A63 Castle Street Improvement, Hull

TR010016

Applicant's comments on additional information or submissions received by Deadline 5

Version	Date	Status of Version
Rev 0	27 August 2019	Final

Levels Study - Preferred

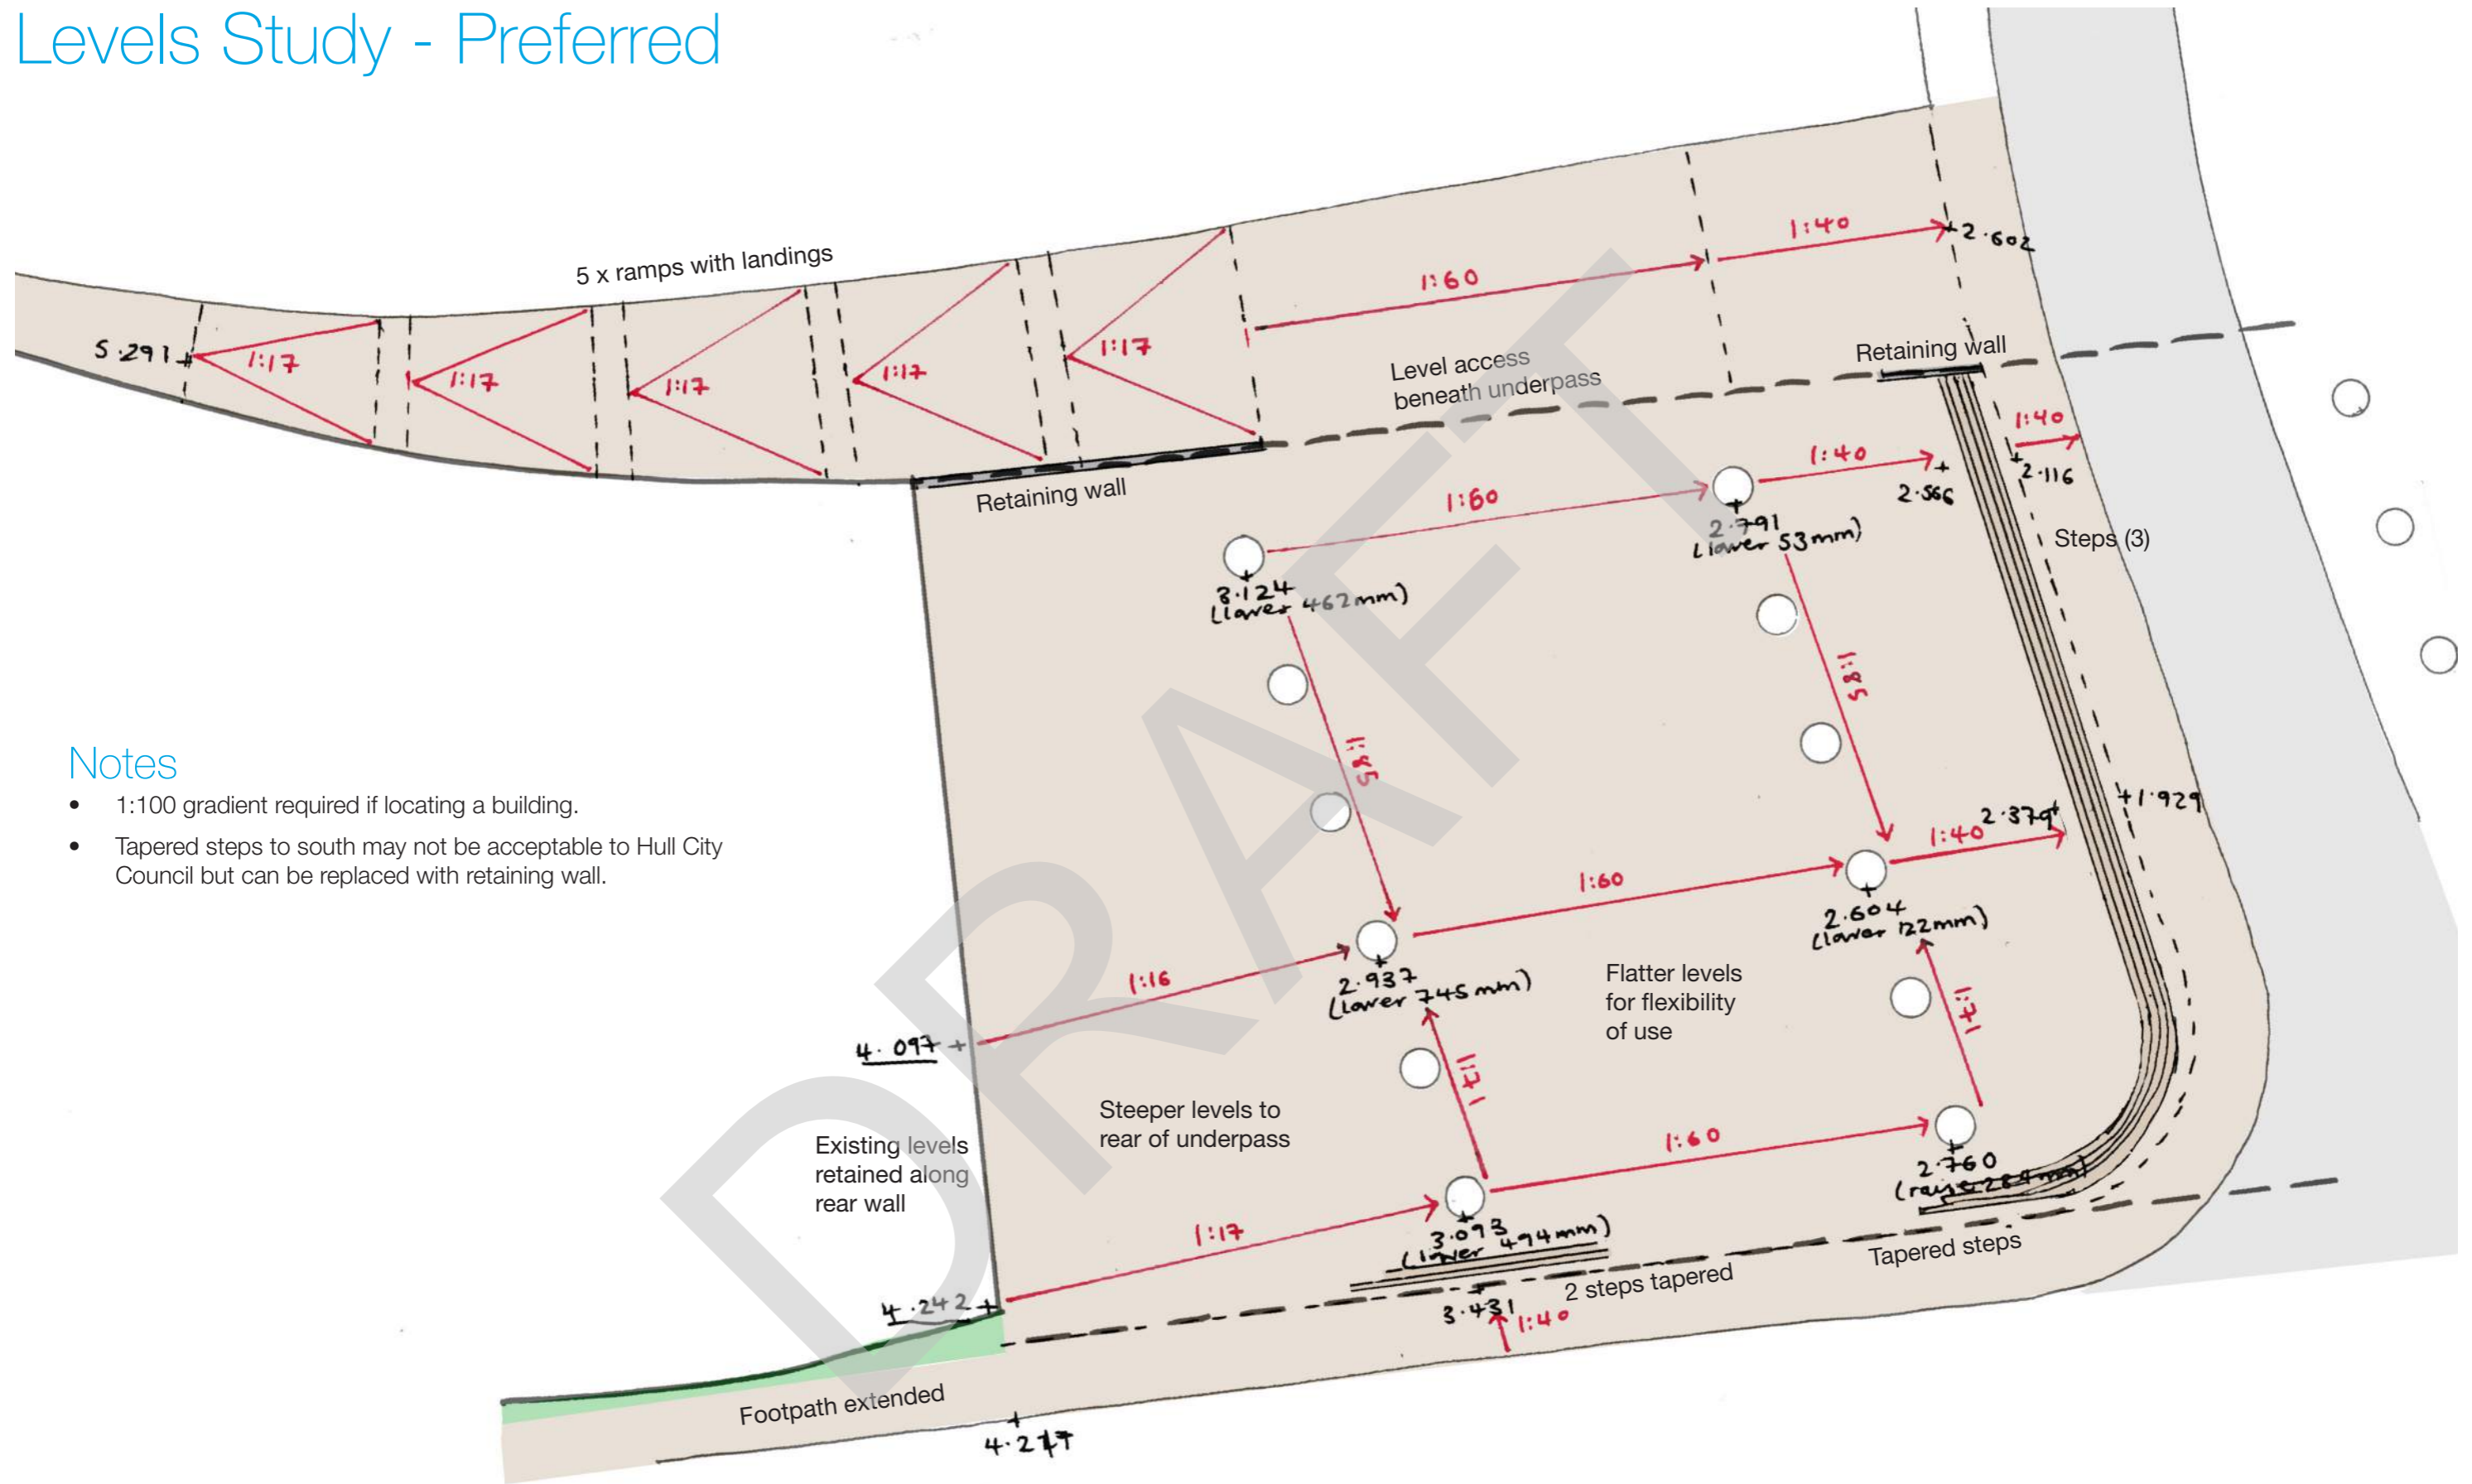
ExQ2	Question to:	Question:	HCC response
2.7	Transportation and Traffic		
2.7.2	The Applicant, HCC, HAIG, East Yorkshire and Derwent Area Ramblers	<p>Myton underpass design</p> <p>The Council's suggested additional requirement, which would require details of the design of the Myton Bridge underpass, is noted (HCC's Post-Issue specific Hearings submission [REP3-215]). Have any design principles or details yet been agreed? If not, what evidence is there that a mutually satisfactory design can be achieved?</p>	<p>HCC wishes to reiterate that this element of the scheme remains a distinct and fundamental concern. Given the removal of at grade NMU crossings over the A63 at the eastern end of the city centre, this route is set to become critical in connecting the city centre to its waterfront and associated regeneration areas, and providing an accessible alternative for all users, both during construction and operation.</p> <p>HCC consider that an environmental upgrade of the underpass is justified and necessary for the scheme to deliver truly on its objective to enhance connectivity, and mitigate for extended travel distances for NMUs, and comply fully with the DfT's Cycling and Walking Investment Strategy, the Applicant's Accessibility and Cycling Strategy, paras.3.16 and 3.17 of the NN NPS, and Policy 25 of the Local Plan.</p>

ExQ2	Question to:	Question:	HCC response
			<p>In the continued absence of sufficient design details for the proposed base scheme, and reliance on frozen designated funds for uplift, notwithstanding constructive consultation around the issue with the both council officers and representatives from HAIG, including a beneficial walk through held on 2nd July, and discussion around broad design principles at a subsequent landscaping design meeting, HCC consider that it is essential that the additional requirement features within the DCO.</p> <p>The Council and its partners in the 'Living with Water' project have identified the underpass as a location suitable to benefit from secured public art funding associated with flood risk and water management. Adjacent to the River Hull and near to its confluence with the Humber estuary, in the shadow of the River Hull tidal surge barrier, and on one of the main pedestrian approaches to the Deep aquarium, the site is considered to have great potential, and the Council is very keen to work with the Applicant to pool ideas and resources towards maximising the quality of experience for route users.</p>

<p>HCC note the following <i>'in the continued absence of sufficient design details for the proposed base scheme, and reliance on frozen designated funds for uplift, notwithstanding constructive consultation around the issue with the both council officers and representatives from HAIG, including a beneficial walk through held on 2nd July, and discussion around broad design principles at a subsequent landscaping design meeting, HCC consider that it is essential that the additional requirement features within the DCO'</i>. It should be noted that preliminary design (of which the DCO is based on) has been shared with all parties, including HCC and HAIG. Meetings have been held in a workshop format and on site and the feedback on the proposals was overwhelmingly positive. Detailed visualisation were also presented to all parties which again were well received. The comments from the group centred around the step detail on the corner Blackfriargate and High Street which will be picked up at detailed design stage.</p>

<p>The Applicant's Response 2.7.2</p> <p>The Applicant notes the importance of the High Street underpass to HCC as the proposed route around Market Place crossing closure. The Applicant has worked very closely with HCC highways officers, access officers, HAIG, designers and developers adjacent to this route during the scheme development. Workshops have been held, a walk with HAIG was held and visualisations for the route have been prepared and shared. They have been appended to The Applicants D6 submission for the ExA to consider.</p>

ExQ2	Question to:	Question:	HCC response
		<p>The base scheme proposals, therefore entirely funded by the Scheme, indicate that the route between Market Place and Queen Street will be upgraded to:</p>	<ul style="list-style-type: none"> - Improve accessibility in line with guidance (dropped crossings and smoother ramp gradient); - Provide enhanced street lighting and urban lighting (up / down lighters for the bridge piers) on the route; - Improve the footways and align this with material used following the significant public realm work completed by HCC; - Provide CCTV infrastructure; - Cut back the levels of overgrown vegetation and provide a new low maintenance planting proposal for the route.
		<p>The visualisations provided by The Applicant show that this area is to be significantly improved compared to current levels. The Applicant, by agreeing to uplift the footway material and provide additional up/down lighters under the structure is going above and beyond of the minimal provision that would be expected. This has been agreed between The Applicant and HCC as it will become the only way for people to cross between the north and the south of Castle Street in this vicinity.</p>
